Bioregional’s response to application 21/03177/F - Axis J9, Phase 3 Howes Lane Bicester

Application description: Full planning application for employment development (Use Classes E(g)(iii), B2 and/or B8) and associated parking and servicing, landscaping and associated works

Figure 5.3: Planting Strategy (Drawing Reference No. 0897-RFM-XX-00-DR-L-0003)

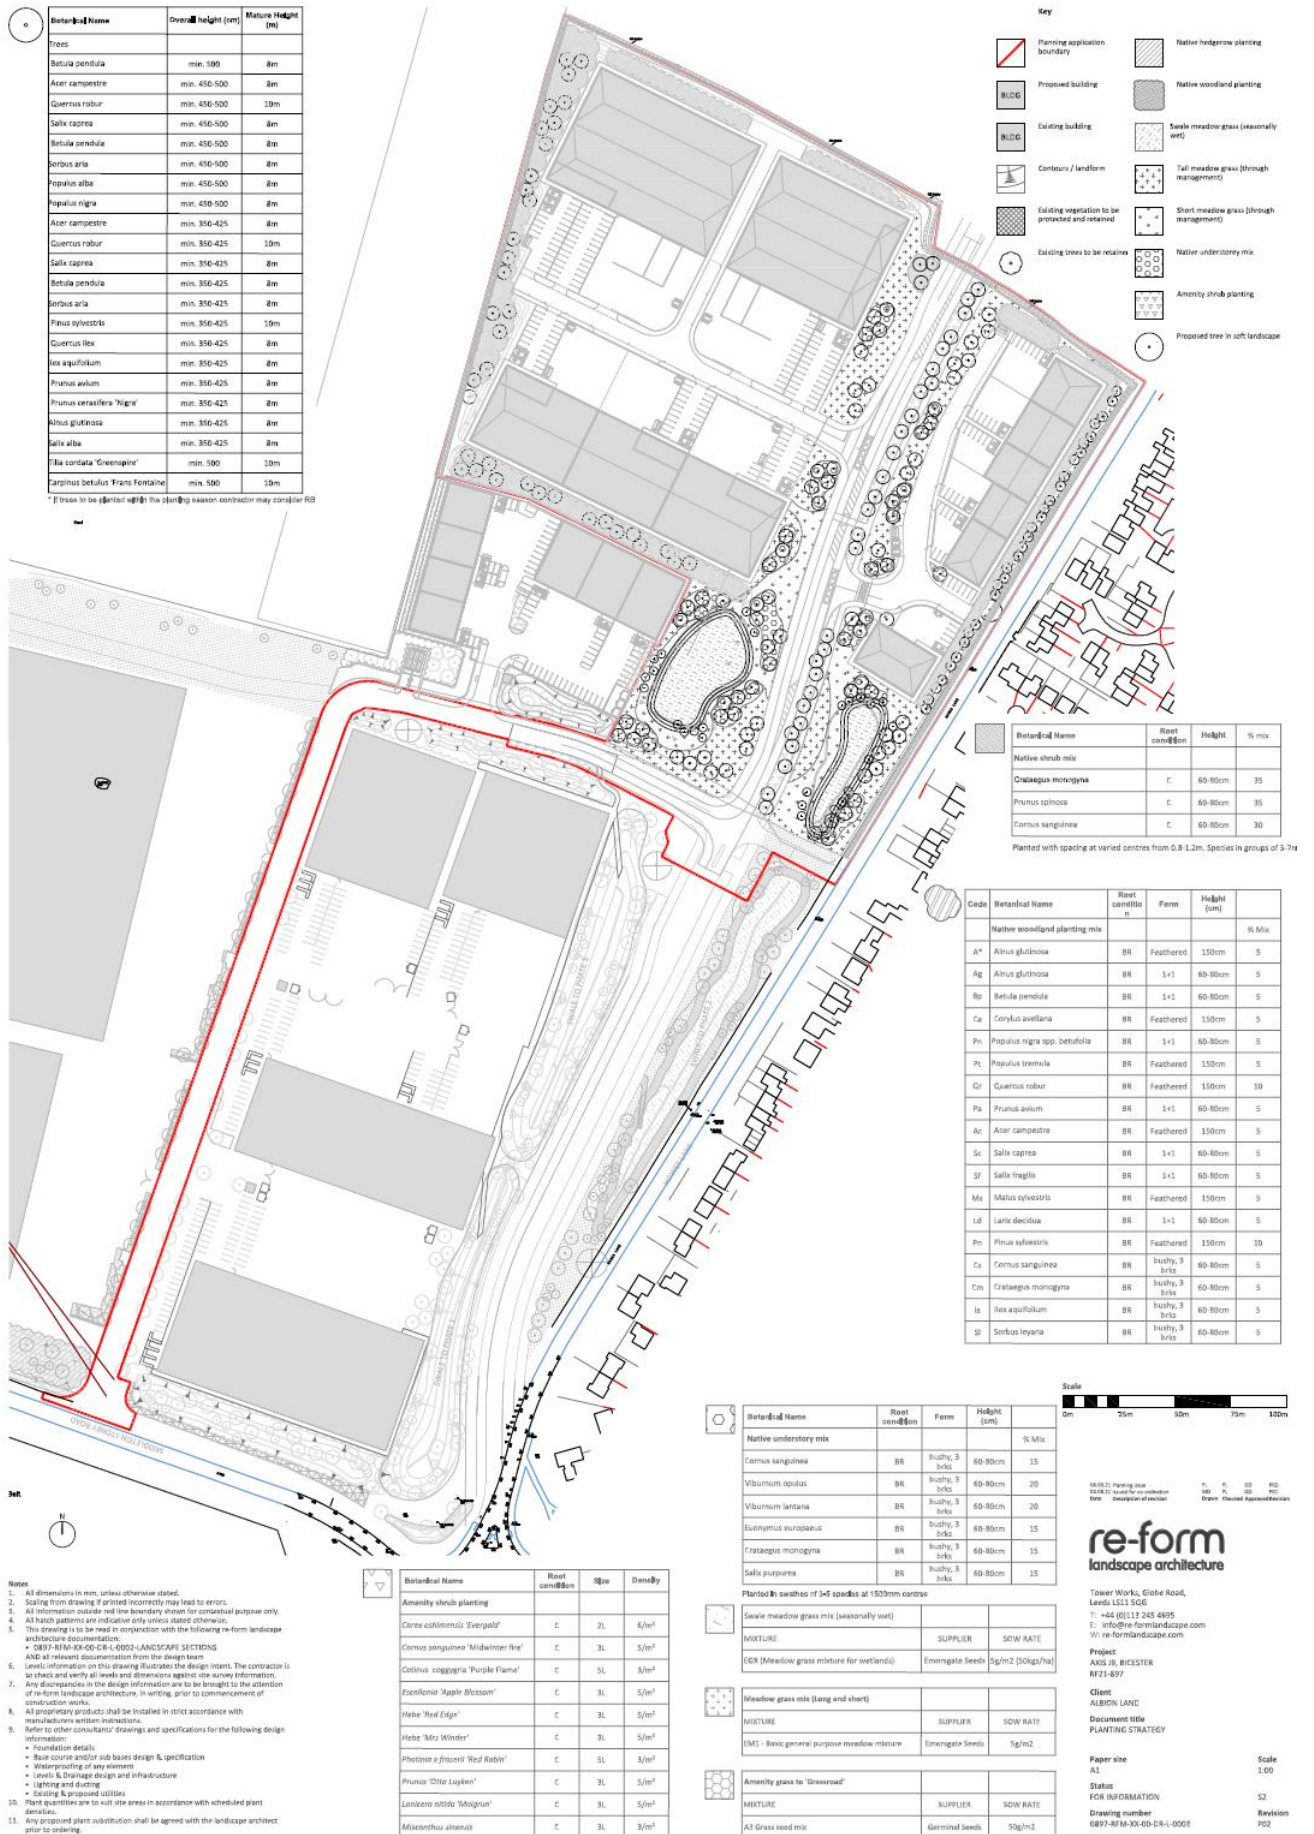
| A layout that maximises the potential for walkable neighbourhoods. | <p>It is stated in the Design and Access Statement that the “building entrances are located in a prominent position creating a safe and pedestrian friendly entrance”.</p> <p>The landscape plan shows a car-dominated landscape, with one pedestrian crossing over the central road.</p> | Design and Access Statement, Cornish Architects, September 2021 | <p>As the proposed development is for industrial/warehouse buildings we would not expect to see significant pedestrian infrastructure.</p> <p>However, further details of safe walking routes should be provided, including evidence to demonstrate segregated routes for pedestrians and cyclists. We would also request to see evidence of wayfinding and signage to nearby public transport nodes (including train station and bus stops).</p> |
